**Stantec Architecture Inc.**  
722 12th Street NW Suite 100, Washington DC 20005-3957

**Reference:** New Mexico Proton Advanced Cancer Therapy (NMPACT)  
Response to Development Review Board Comments  
Project: PR-2022-007588  
Application: SI-2022-01658

Title
DRB SITE PLAN

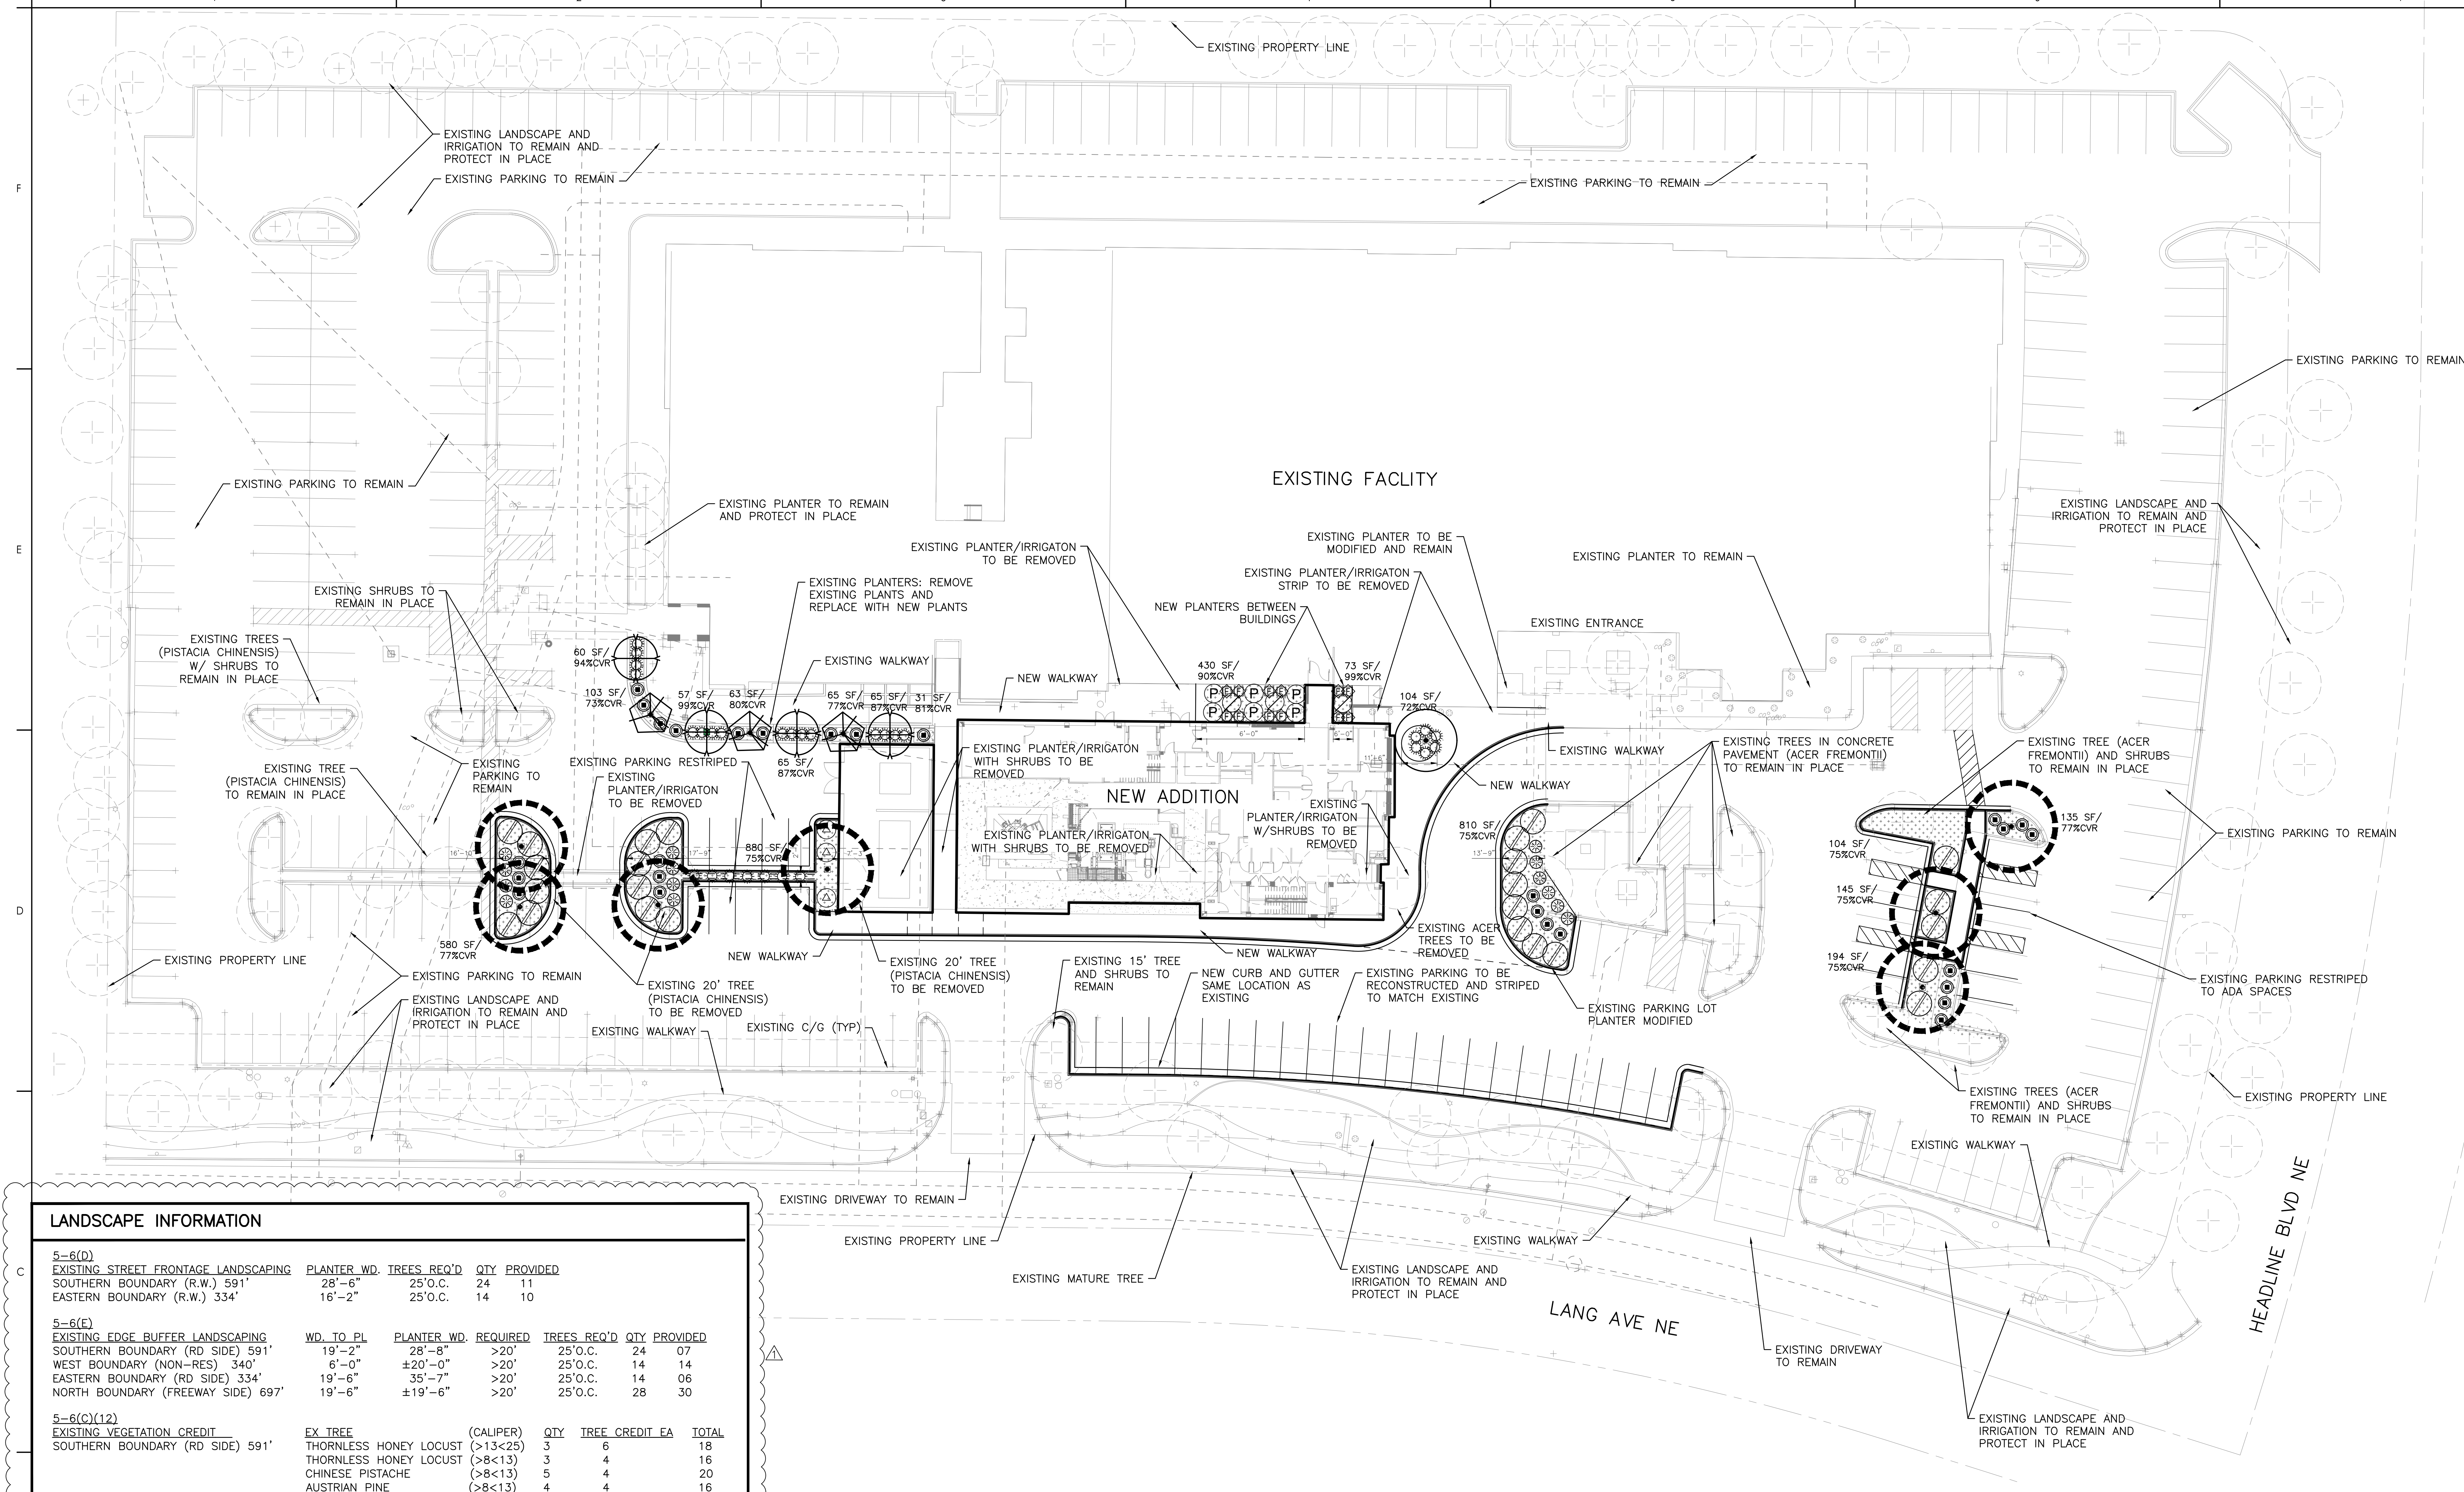
1. The Journal Center Master Plan and the Site Plan for Building Permit per 1000560 / 06DRB-01023 both govern the site. Where they are silent, all development must meet standards and provisions of IDO (NR-BP), the DPM and any related Use Specific Standards.
  - a. Please provide a copy of the existing site plan if available.
    - i. *Stantec Response: The existing approved Site Plan was submitted with the application, and it is attached to this letter.*
  - b. On the Site Plans or site plan notes, please include detailed and relevant development information to help clarify new expansion and modifications. For example, setback & height measurements, buffer measurements, parking & landscaping calculations, new uses and/or changes in use.
    - i. *Stantec Response: We have prepared Sheet A1-10, DRB Site Plan with the required information. Please see the attached.*

- a. *Stantec Response: Sheet C-102, Solid Waste Plan has been approved. See attached.*
6. The Parking Tabulation section of the Site Plan notes that the parking requirements for the site are based on the previously approved site plan plus the addition at current parking rates. The overall indication is that there is potentially a parking shortage per IDO requirements. Staff has talked to the applicant about sections of the IDO where parking reductions could apply and awaits a resubmittal on parking for the site.

7. The Parking Tabulation section of the Site Plan notes that 100 parking spaces will be provided off-site. If any off-site parking spaces will be utilized and will count toward the total of number of required parking spaces, a recorded Shared Parking Agreement will be required for those parking spaces and must be submitted prior to the approval of this Major Site Plan Amendment – DRB.

- a. *Stantec Response: A Parking Report has been prepared. The purpose of the study is to provide the Planning Director for the City of Albuquerque with the information necessary to consider a reduction of parking requirements for this project. See attached report.*

- a. *Stantec Response: The Owner understands the requirement and will record a Shared Parking Agreement if required.*
8. The number of bicycle parking spaces which are required are depicted in the Parking Tabulation section, but the number of bicycle spaces/racks which are being provided is not depicted. That information needs to be added to the Site Plan.
